SSD 7382 UTS Central, Broadway Precinct

Detailed Response to Submissions – July 2016

Existing June 21st 12:00pm Shadow

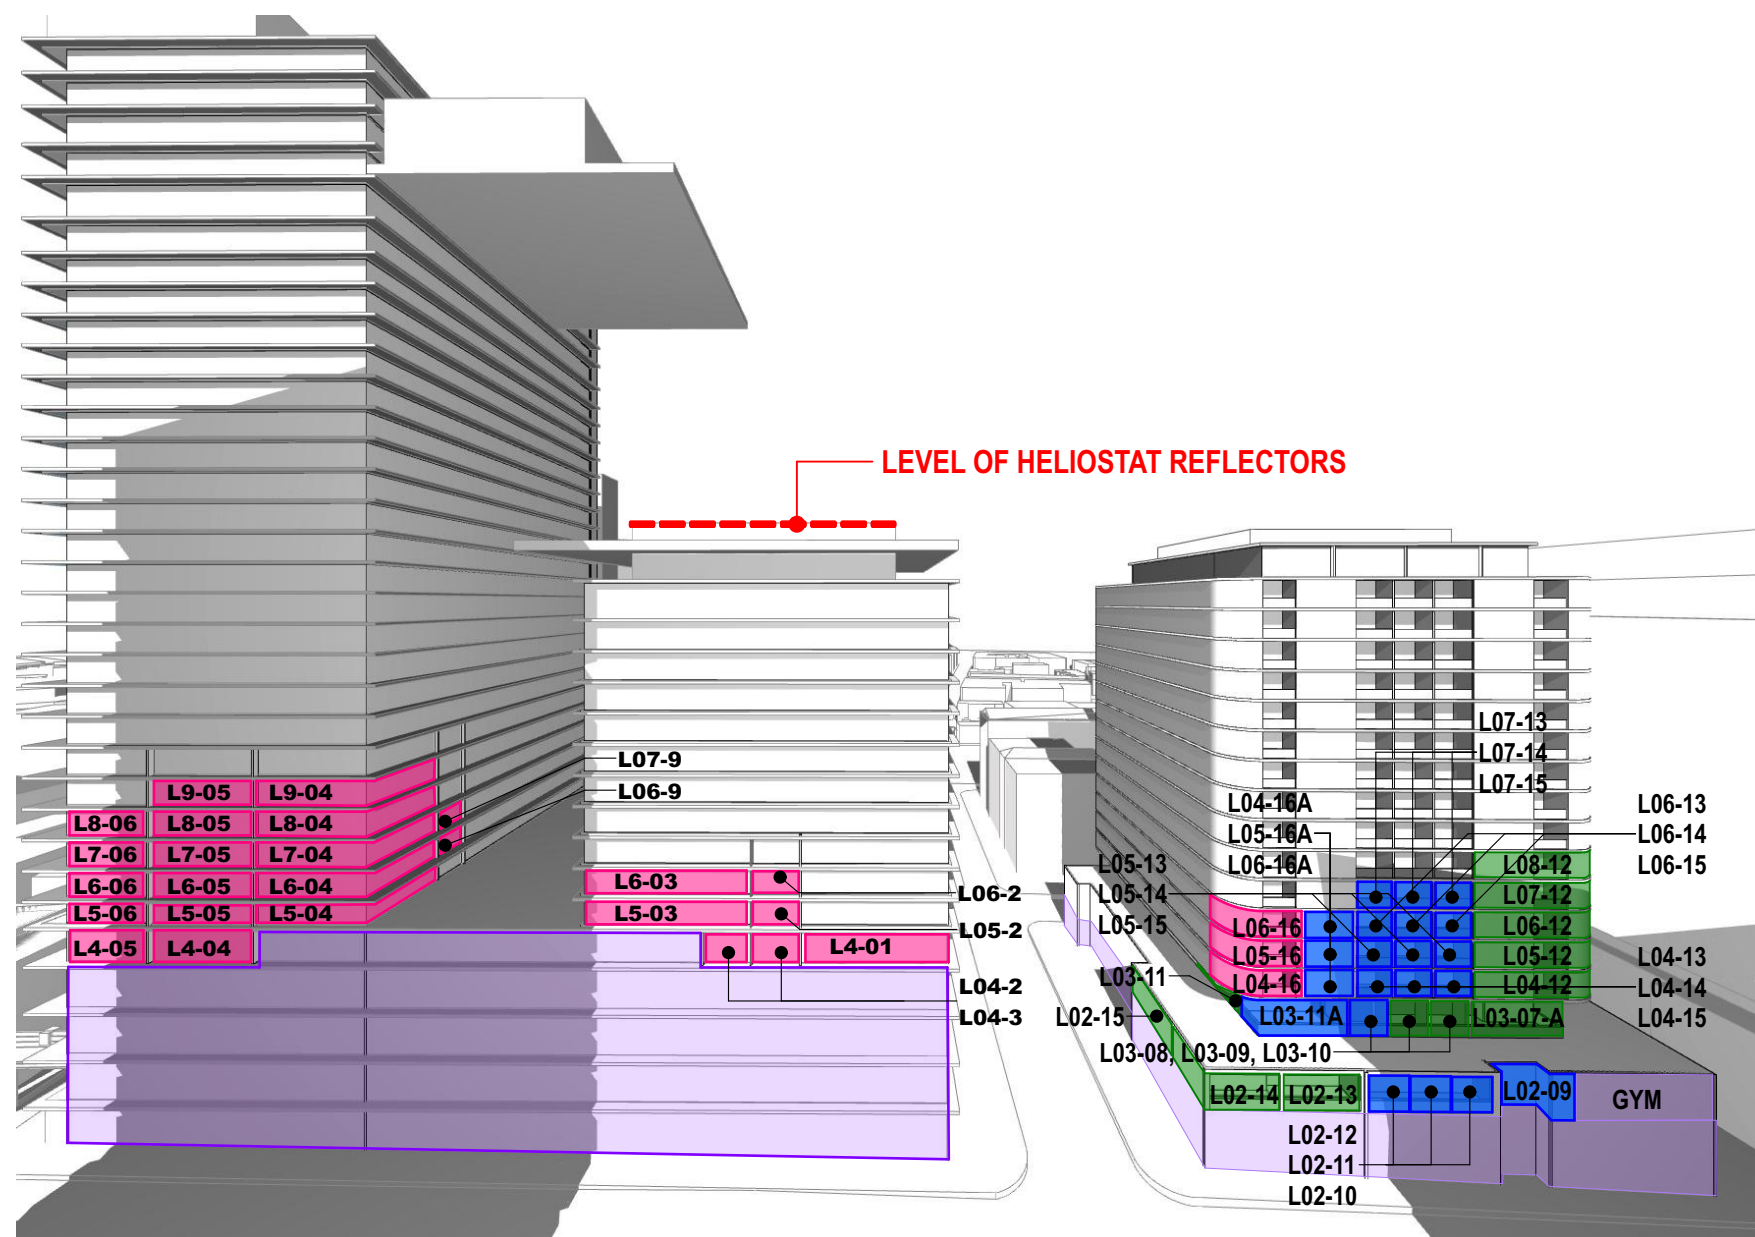
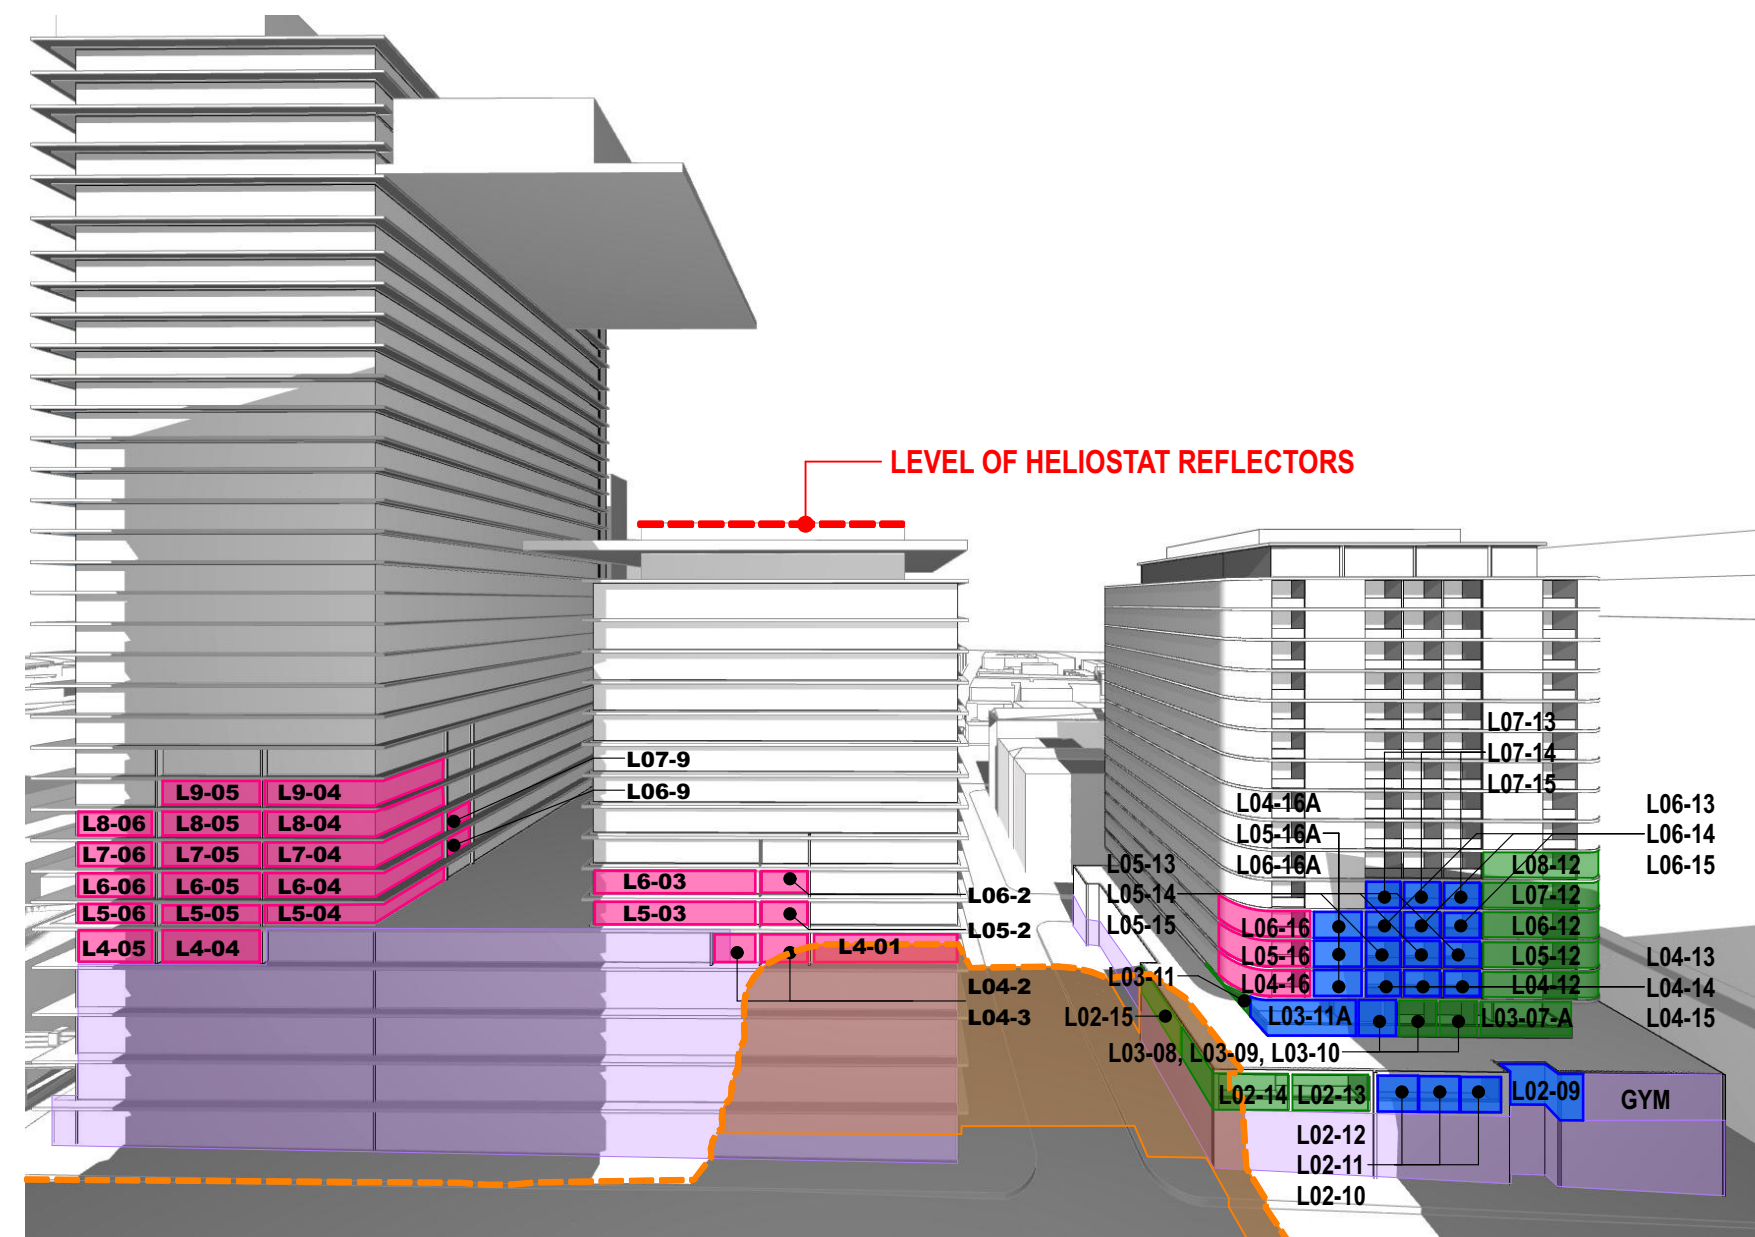
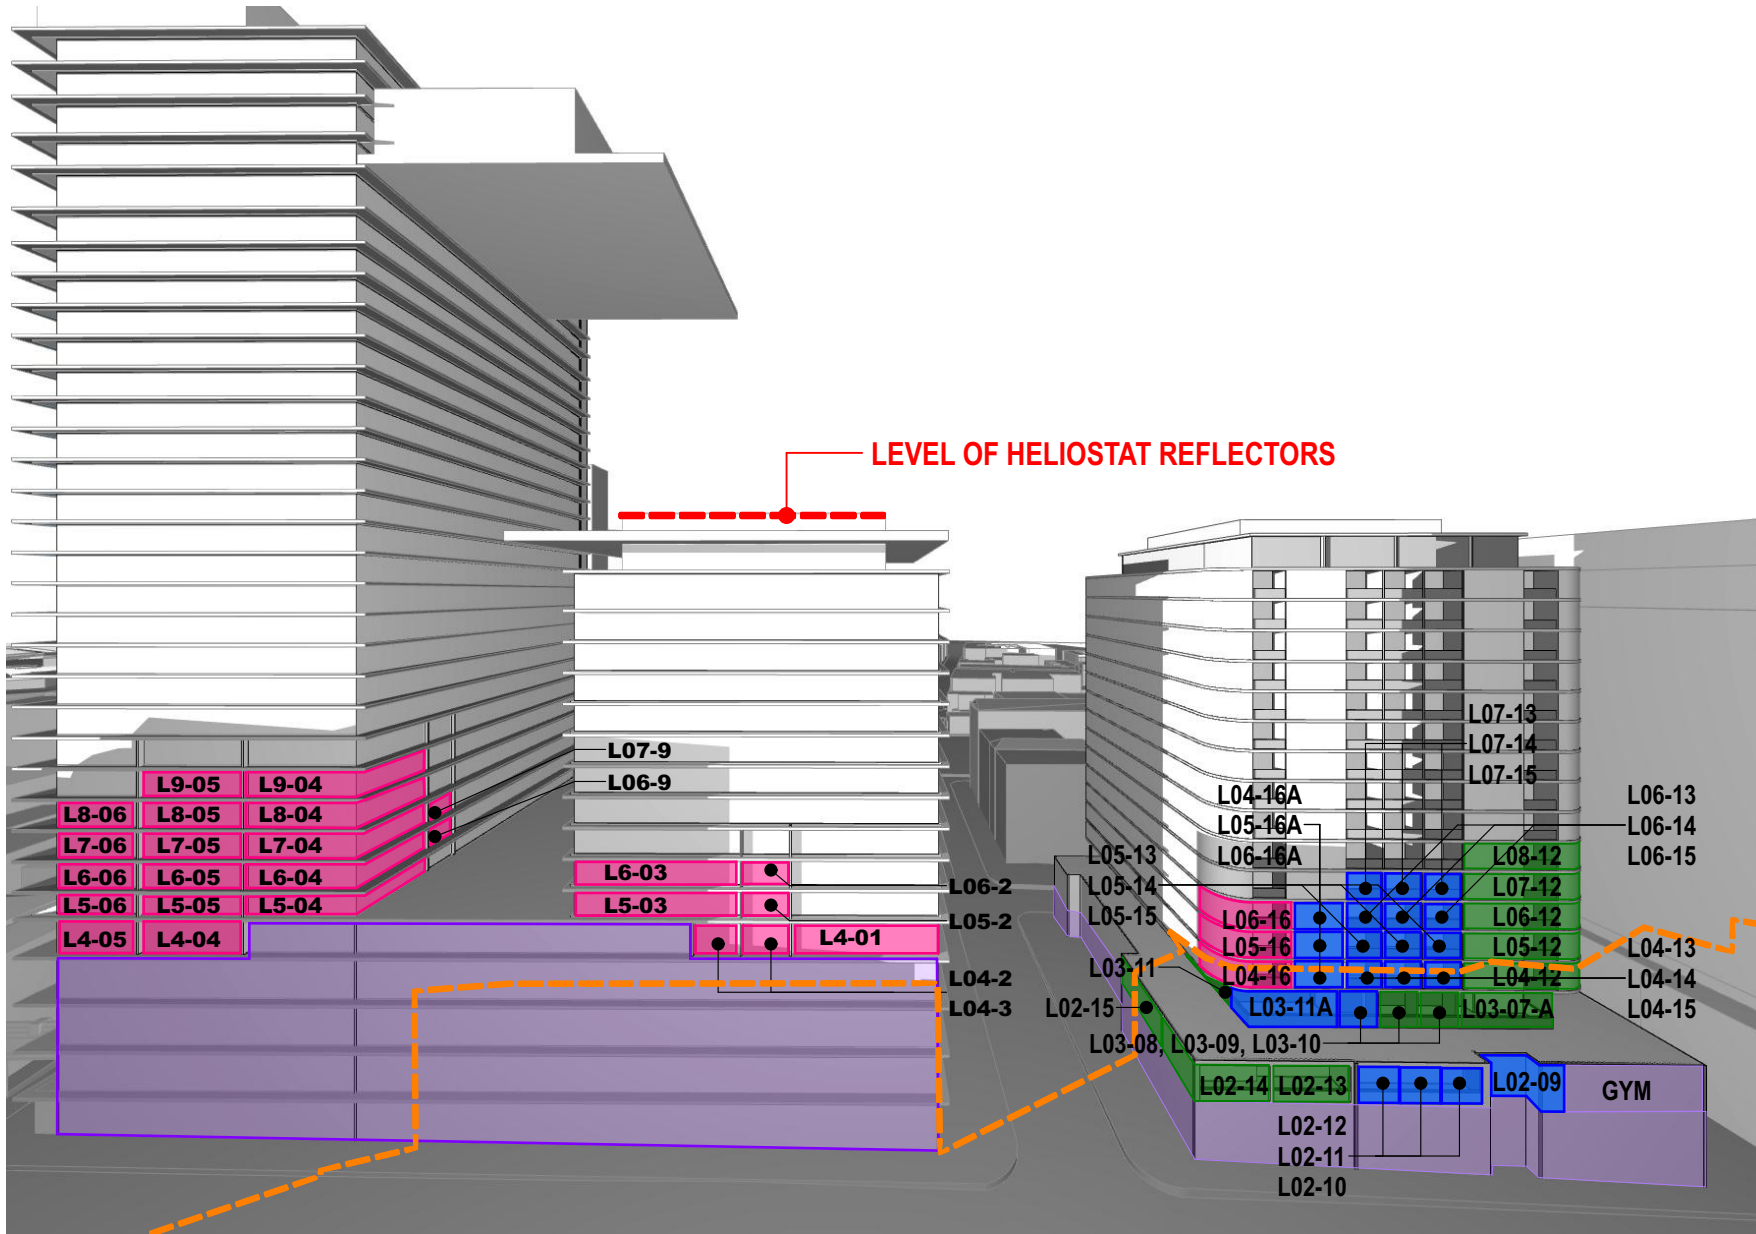
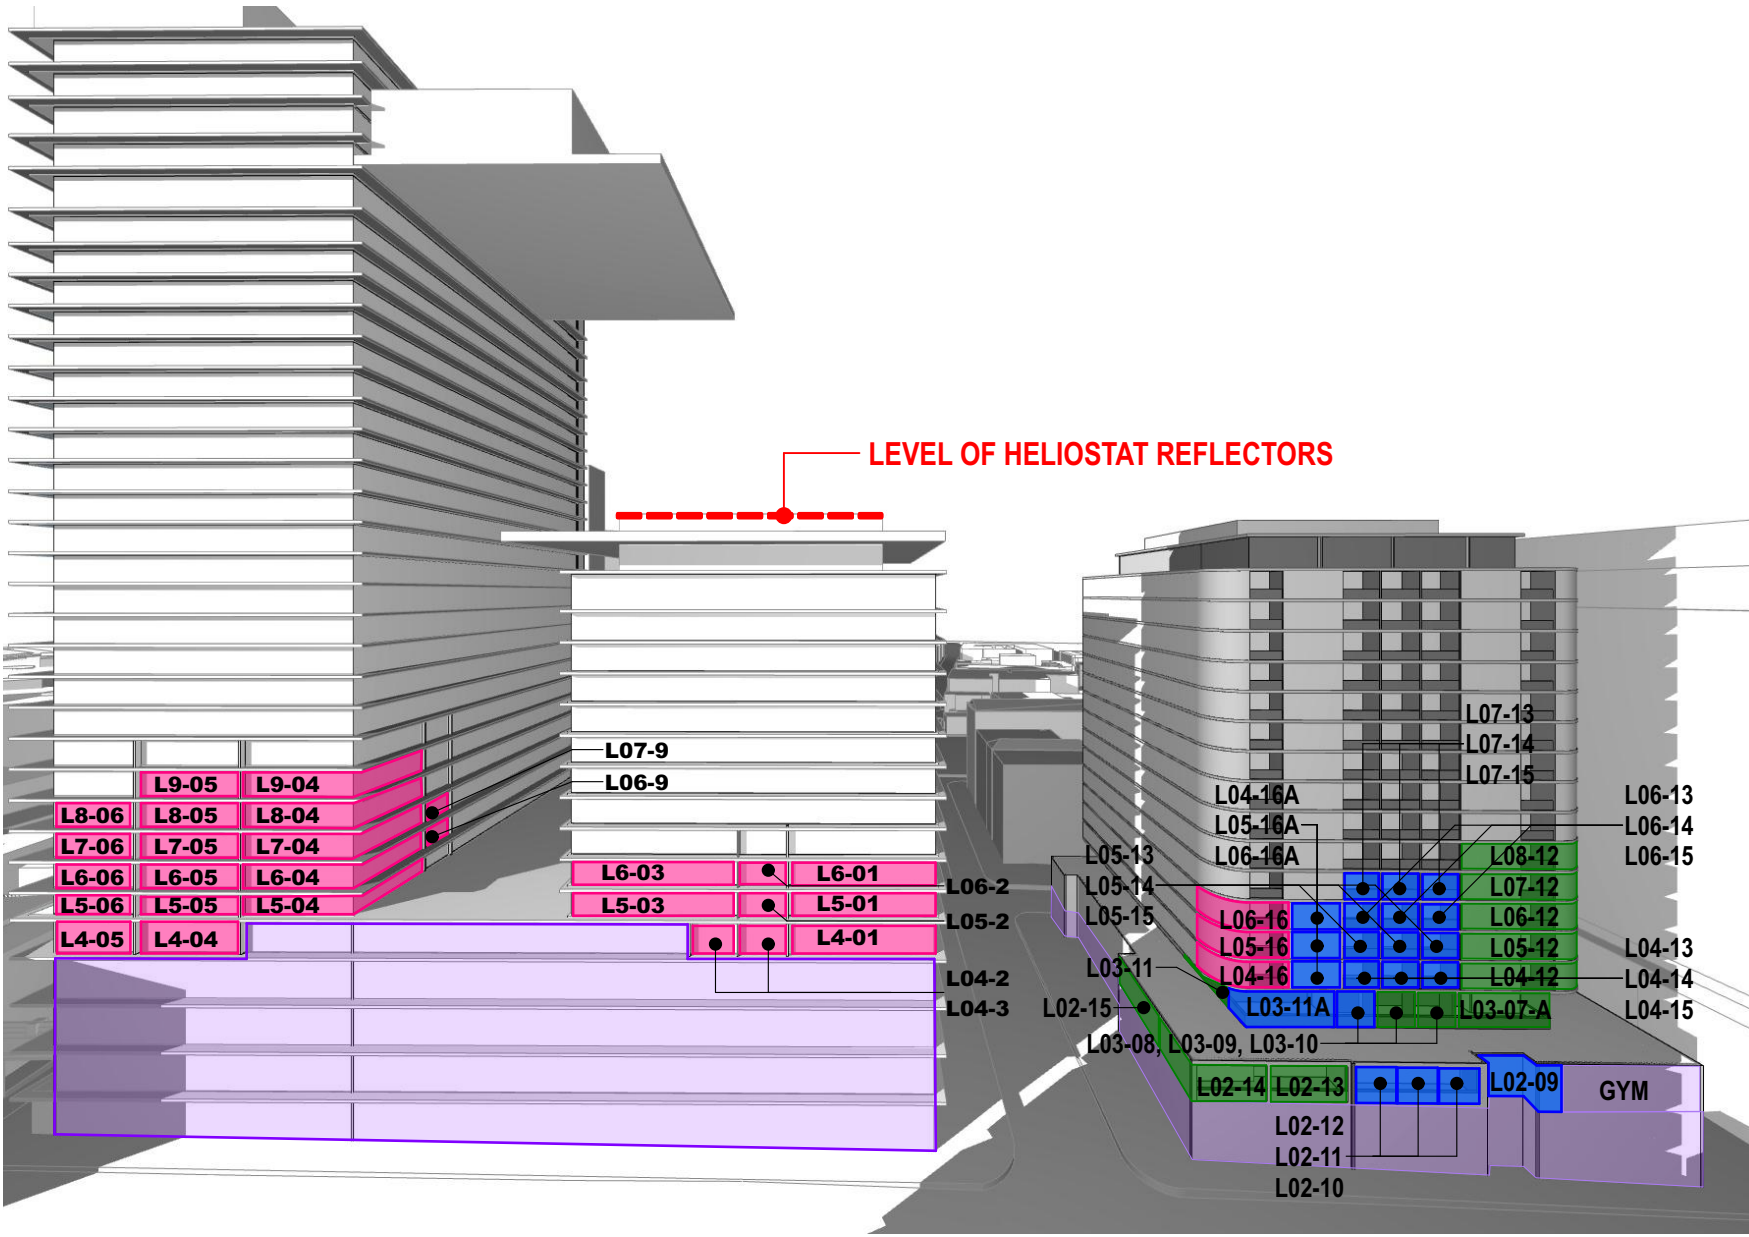
<p>Environmental and Residential Amenity</p> <p>5. The Department is concerned with the overshadowing impacts from the proposed building on the residential properties within Central Park and a further quantitate analysis of solar access to be retained and lost for all dwelling impacts by the proposal must be provided, including additional analysis of whether the proposal would impact on any heliostat solar collectors for building within Central Park.</p>	<ul style="list-style-type: none"> - FJMT and JBA have completed a detailed analysis on the overshadowing impact from the proposed building on the residential properties within Central Park as outlined within the main report. - The holistic assessment of the various amenity considerations for Block 1 demonstrates that notwithstanding the lower achievement of direct sunlight access, Block 1 will deliver a high level of residential amenity. - The proposed development is the same height as the lower tower of No. 1 Central Park and does not impact on the roof level of the lower tower where the reflectors are located or the roof level of the higher tower where the heliostat is located.

Solar & Daylight Access <p>In order to demonstrate that the proposed development is able to comply with Objective 3B-2 of the Apartment Design Guide and Section 4.2.3.1 of the Sydney Development Control Plan 2012, a solar analysis should be provided of the surrounding buildings and rooftop on which the heliostat solar collectors are located. A daylight report and LUX level map of affected apartments should also be submitted.</p>		<ul style="list-style-type: none"> - Detailed elevational shadow diagrams for Central Park (One Central Park and Block 1) have been prepared by FJMT (Attachment B) for June 21 (7.30am to 3pm) illustrating: <ul style="list-style-type: none"> - Shadows Cast by the modified Concept Plan (MOD 5 envelope) - Shadows cast by UTS Central SSDA. - Further, the existing building shadows cast over Central Park have been previously prepared and are also submitted with this report. - The proposal has been reviewed against the following: <ul style="list-style-type: none"> - <i>Objective 3B-2 of the Apartment Design Guide.</i> - <i>Section 4.2.3.1 of the Sydney Development Control Plan 2012.</i> - As outlined within the main report, the holistic assessment of the various amenity considerations for Block 1 demonstrates that notwithstanding the lower achievement of direct sunlight access, Block 1 will deliver a high level of residential amenity.
